SEVENOAKS DISTRICT COUNCIL
PARISH /TOWN COUNCIL PLANNING APPLICATION
CONSULTATION RESPONSE

Reference :	SE/19/05000/HYB (REVISED 2020-07)
Site :	Fort Halstead Crow Drive Halstead
Proposal :	<p>Hybrid application comprising, in outline: development of business space (use classes B1a/b/c) of up to 27,773 sqm GEA; works within the X enclave relating to energetic testing operations, including fencing, access, car parking; development of up to 635 residential dwellings; development of a mixed use village centre (use classes A1/A3/A4/A5/B1a/D1/D2); land safeguarded for a primary school; change of use of Fort Area and bunkers to Historic Interpretation Centre (use class D1) with workshop space and; associated landscaping, works and infrastructure. In detail: demolition of existing buildings; change of use and works including extension and associated alterations to buildings Q13 and Q14 including landscaping and public realm, and primary and secondary accesses to the site</p> <p>PROPOSAL AS PER 2019-11 RESPONSE FROM DGPC Hybrid application comprising, in outline: development of business space (use classes B1a/b/c) of up to 27,659 sq m GEA; works within the X enclave relating to energetic t

Site location and parish boundaries

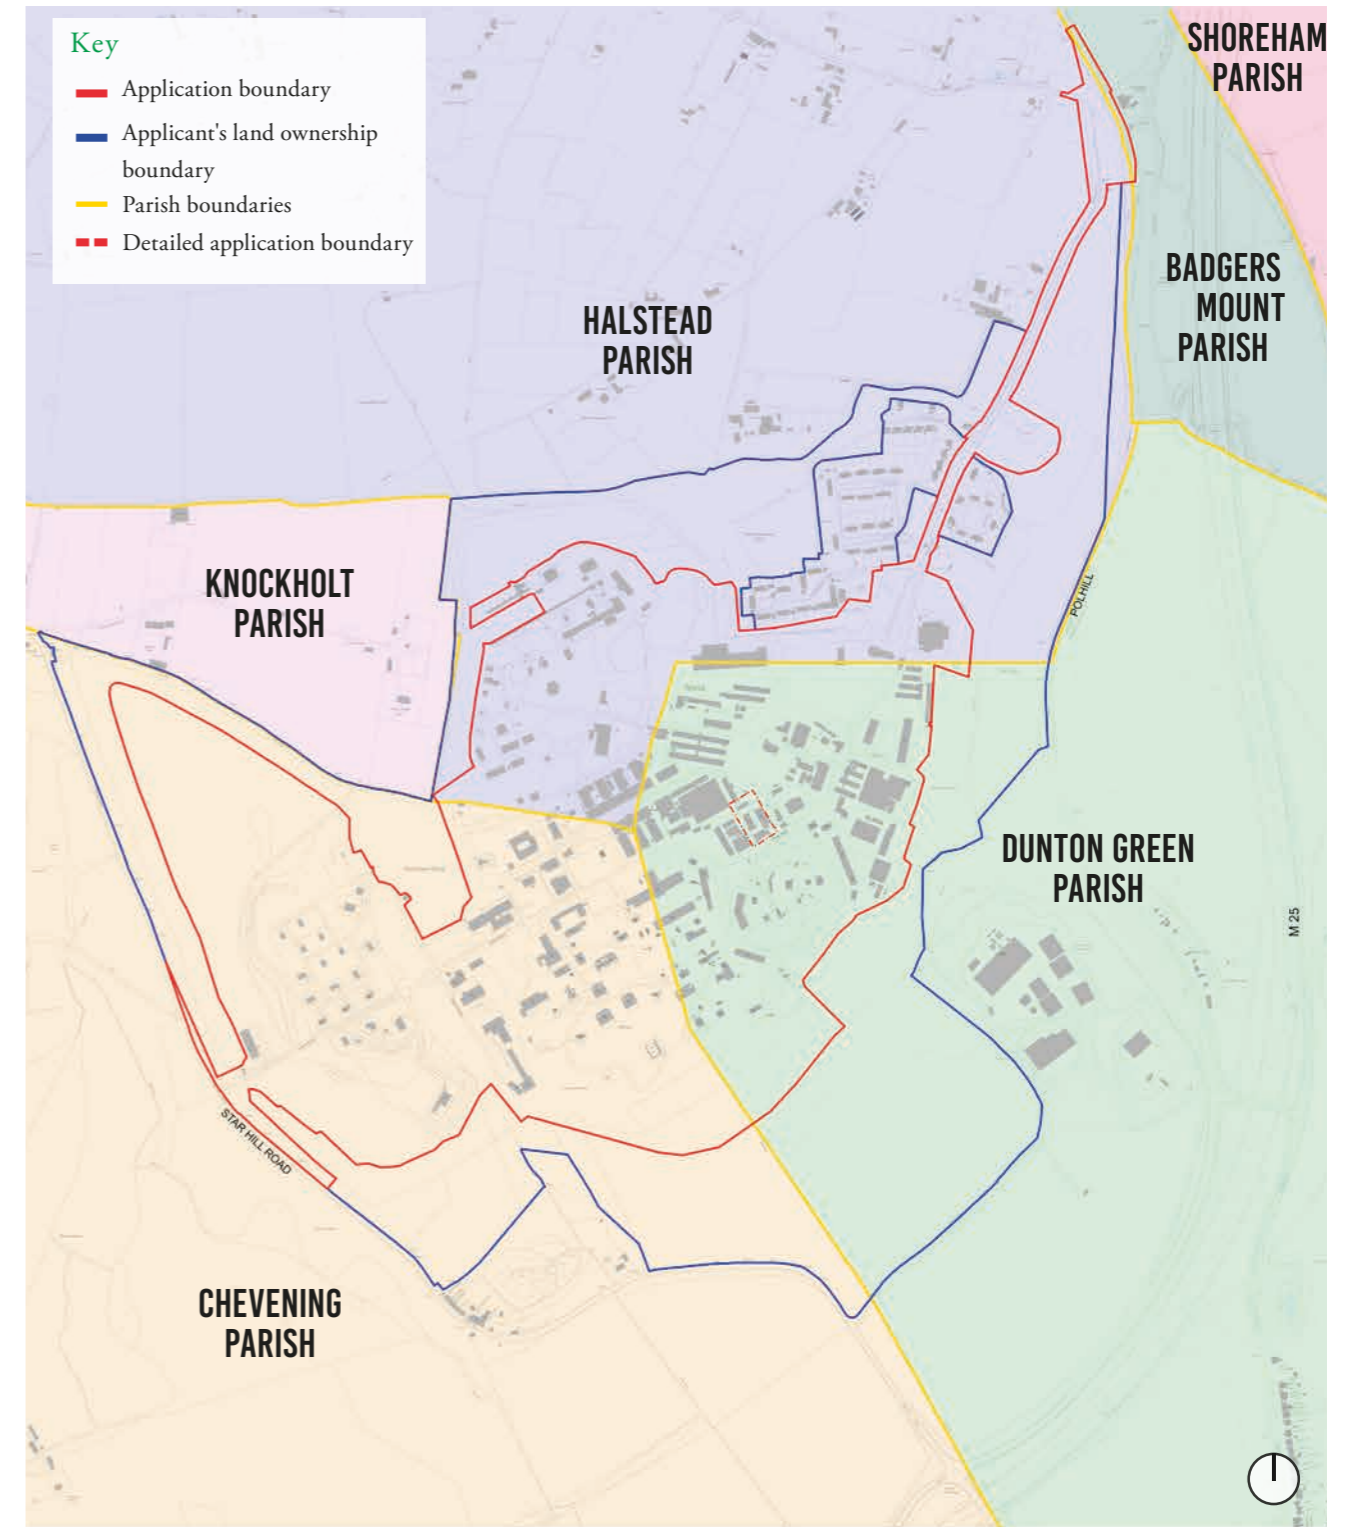
P16 Map identifying site location and parish boundaries.

A significant proportion of the development lies within the parish boundary of Dunton Green, including the bulk of the so-called 'village centre' and a significant proportion of the residential development. Dunton Green has taken the brunt of social housing in the district for several years and the parish does not want more within its boundaries. The village is already threatened with a further 250 homes on land adjacent to its recreation ground (albeit this development has, at this stage, been removed from the Local Plan) and this Fort Halstead proposal indicates that there will be a significant amount of building in Dunton Green. The development that is identified within the Dunton Green parish boundary should not include a high proportion of social housing – other parishes across the district need to start shouldering some of the burden.
